A1 Birtley to Coal House

Scheme Number: TR010031

EXA/D5/002 Applicant's Response to Deadline 4

Applicant's Response to Deadline 4 Submissions

**Applicant's Response to ExA's Second Written Questions
- Appendix 2.5A - Angel of the North Sketch Proposal**

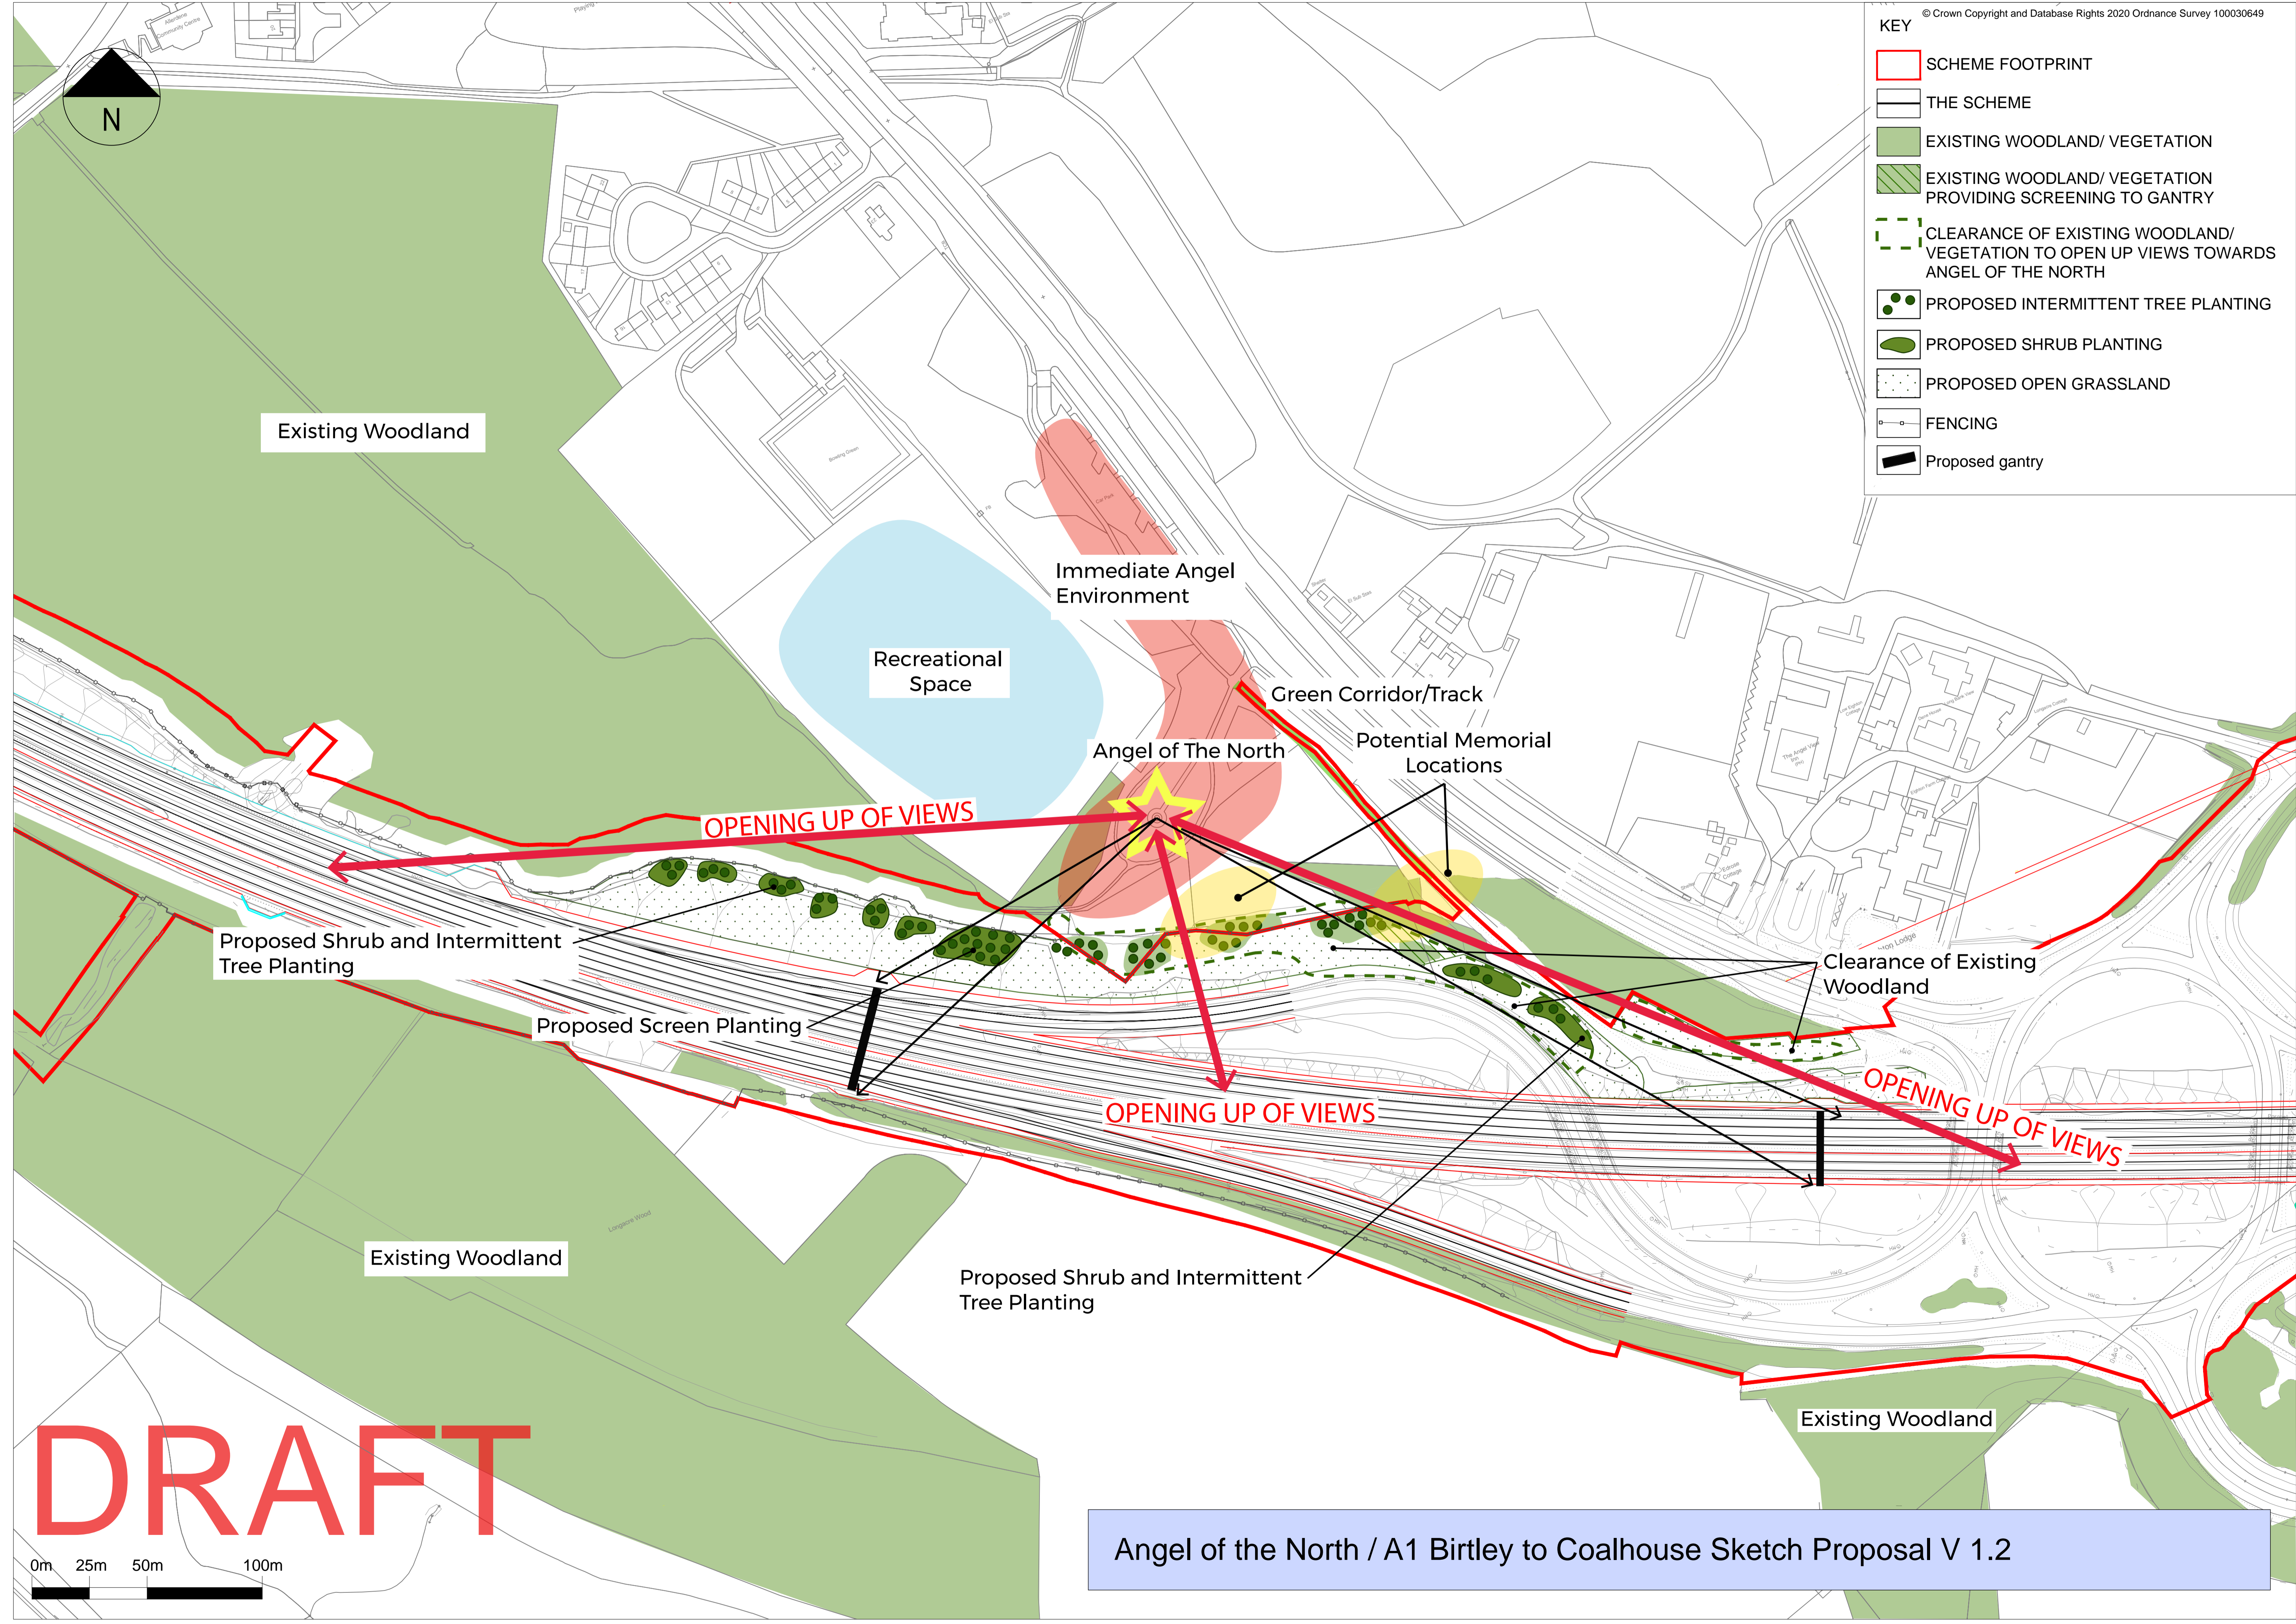
2.5.1.a	I welcome news on any further developments relating to the vegetation management plans that result from Gateshead Council's meetings with the Applicant (2.5.1 a)	<p>Further to the information provided in Applicant's Responses to ExA's Second Written Questions [REP4-052], question 2.6.2, the Applicant has since shared with Gateshead Council (email on 22nd April 2020) an updated plan [refer to Appendix 1A] showing enhanced landscape proposals to support Gateshead Council's vision for the Angel of the North. The Applicant has also provided Gateshead Council with outline proposals for the treatment of the vegetation to be cleared and measures for soiling in order to facilitate the establishment of the species rich grassland, as identified on the plan.</p> <p>Subject to agreement on the proposals, these can be incorporated into the landscape strategy outlined on Figure 7.6: Landscape Mitigation Design [APP-061], along with any further agreed changes to the woodland areas required to ensure that sufficient woodland is provided as replacement habitat, to be issued at a later date. Importantly, these should be recognised as enhancements over and above the mitigation proposed for the impacts of the Scheme.</p>

Northern Gas Networks Land Ownership

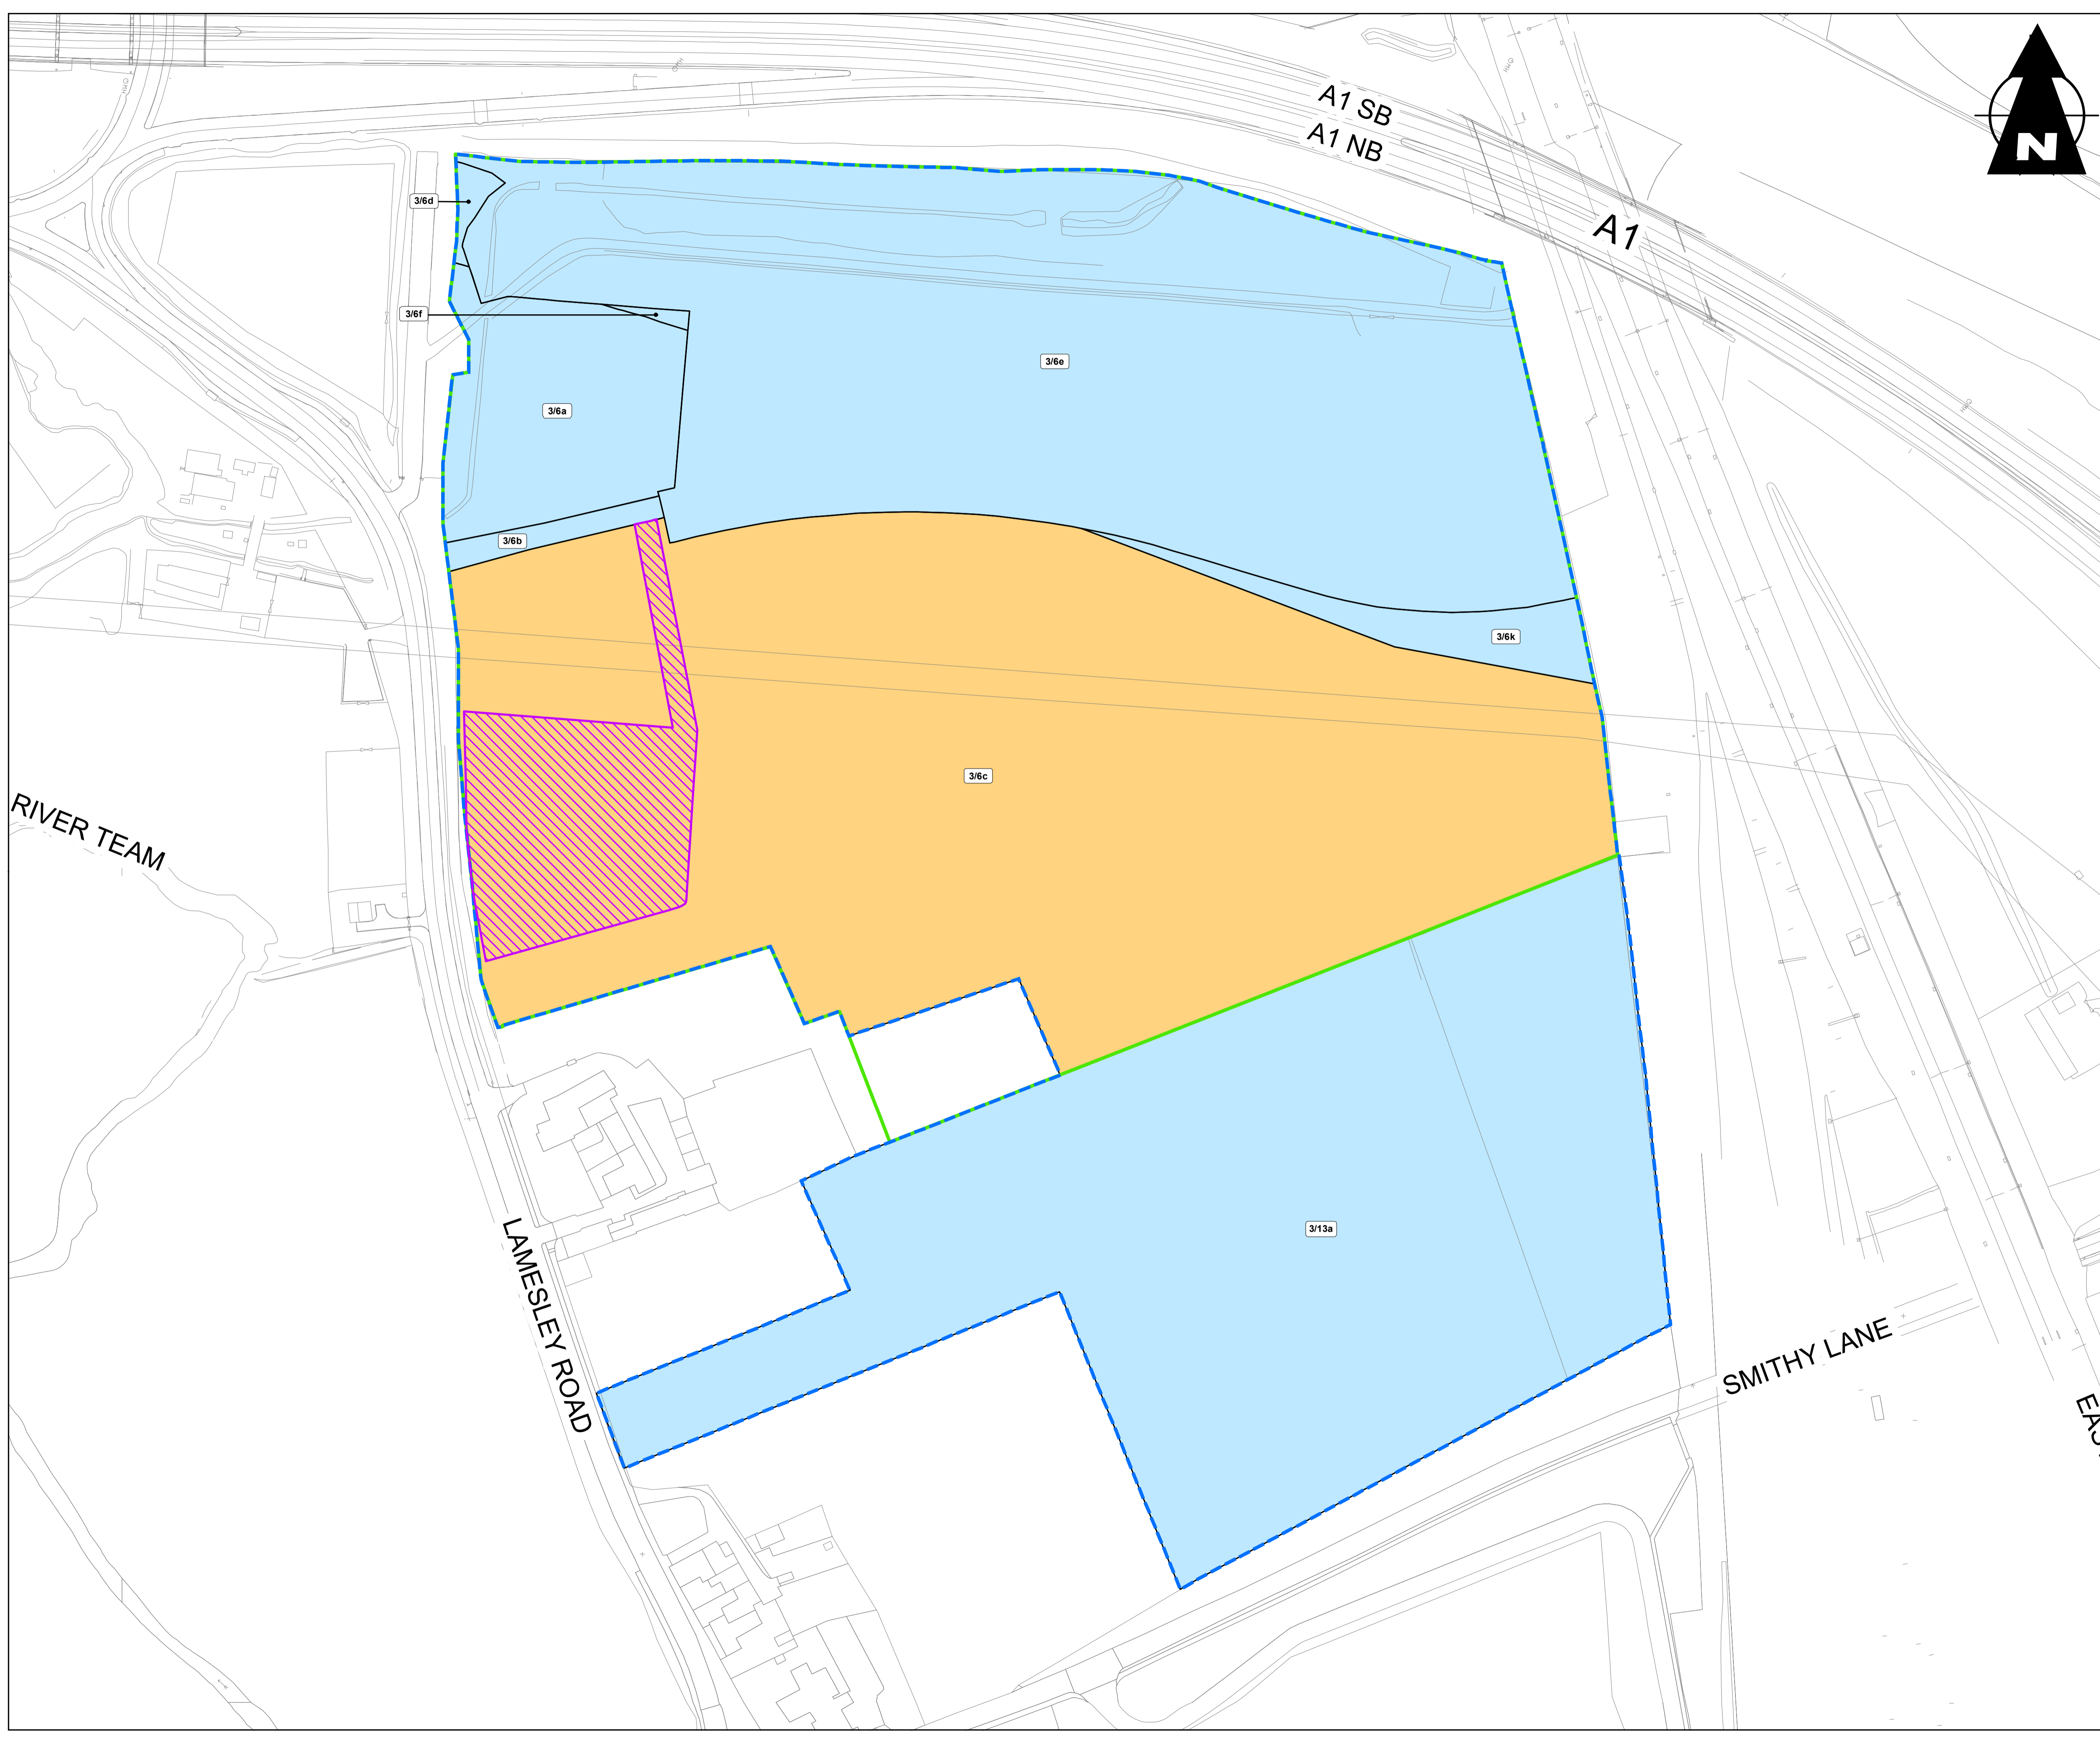
Ref:	Question:	Northern Gas Networks Limited Response:	Applicant's Comment:
2.3.4	<p>Northern Gas Networks Limited (NGN) have submitted representations [including REP1-019] regarding the Applicant's proposed use of Plot 3/6c for a construction compound.</p> <p>a) In the light of such representations from NGN, the Applicant is requested to provide a full justification of its need for the entirety of land within Plot 3/6c, supplemented by any up to date drawings of the construction compound layout.</p>		<p>The Applicant has drafted a Technical Note setting out the justification for the proposed layout and usage of plot 3/6c as a construction compound at junction 67 - refer to WQ Appendix 2.3A [REP4-082]. This refers to the current Scheme design under Examination and does not take account of the material change request submitted at Deadline 4. This request includes a proposal to include additional land at plot 3/13a in relation to a material stockpile adjacent to plot 3/6c.</p> <p>The relevant plan of the compound layout is Figure 1 Site Compound Plan in Appendix A of the Outline CEMP [REP4-022 and 023], an updated version of which was submitted at Deadline 4. This plan also forms Figure 1 of the Technical Note at Appendix 2.3A [REP4-082].</p> <p>The layout of the compound at plot 3/6c as shown on Figure 1 is indicative, showing the likely uses and layout that the contractor may adopt. The areas that have been identified and the different uses of each area is typical of what is required to be provided. The contractor will further review and update the layout once detailed design and construction methods have been finalised.</p> <p>The indicative sizes of each of the areas shown on Figure 1 are set out in the Technical Note, along with justification for the size of each of these areas and the compound as a whole.</p>

Ref:	Question:	Northern Gas Networks Limited Response:	Applicant's Comment:
			<p>The Applicant has reviewed the proposed land for the construction compound and in order to realise design benefits and efficiencies for the Scheme is proposing a material change request at Deadline 4. This includes a proposal to include additional land at plot 3/13a in relation to a material stockpile adjacent to plot 3/6c [REP4-082]. Further details as to the additional land at plot 3/13a are set out in the Addendum to the Statement of Reasons [REP4-084], the Planning Statement Addendum [REP4-055], the Environment Statement Addendum – Additional Land [REP4-058] and shown on the Land Plans [REP4-011].</p>
	<p>b) NGN is requested to provide details of the proposed timetable for each stage of the implementation of the Compressed Natural Gas refuelling station, taking into account the design, planning and construction process.</p>	<p>NGN is able to provide a response to question 2.3.4(b) as follows: NGN is not currently in a position to give a definitive timeline for the implementation of the CNG refuelling station. There are two principal reasons for this: (a) ENGIE, who are currently intending to construct and operate the CNG Refuelling Station has informed NGN that before works can commence on the construction of the CNG Station, it is necessary to have secured customers to use CNG Refuelling Station. This is an important part of the viability assessment process. Whilst this market development is currently underway, there are obvious limits to how far this process can be taken whilst the proposed site is subject to a potential DCO. This process is therefore dependent on when the proposed CNG station becomes available.</p>	<p>NGN has asserted that the CNG filling station is being impeded as to its delivery by the Scheme. However, it remains the case that there is no programme for the delivery of its proposal either with or without the Scheme. Furthermore, NGN has stated that the CNG filling station remains subject to a viability assessment process. Implicitly, the proposal may not proceed, and hence little weight can be afforded to the proposal, however worthy it may be.</p>
